3 July 2018

PINS Reference: EN010091

[Application by Drax Power Ltd for an Order Granting Development Consent for the Drax Re-power Project](#)

[Response to Section 51 advice following issue of decision to accept the application for examination](#)

Application Document Reference 2.5B  
 Single Unit Option  
 Indicative Plant Layout  
 - Gas Pipeline Route - Sheet 8 of 9

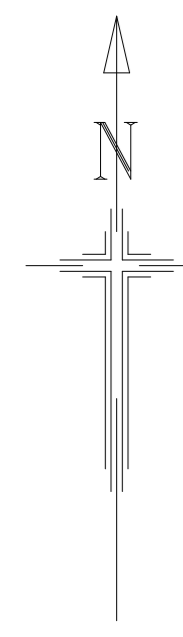
The Section 51 Advice notes that the Indicative Above Ground Installation (‘AGI’) elevations drawing (document reference 2.6C) depicts a building and a nearby satellite dish, however these are not illustrated on either the Indicative Plant Layout plan for the ‘one unit option’ (document reference 2.5B) or the Indicative Plant Layout plan for the ‘two unit option’ (document reference 2.5A) for the AGI (Work 6 ‘above ground gas installation’).

Please find enclosed 3 no. electronic and 2 no. soft copies of the updated Indicative Plant Layout Plans (document references 2.5A Sheets 1 and 8 Rev 02 and 2.5B Sheets 1 and 8 Rev 02) showing the building and satellite dish.
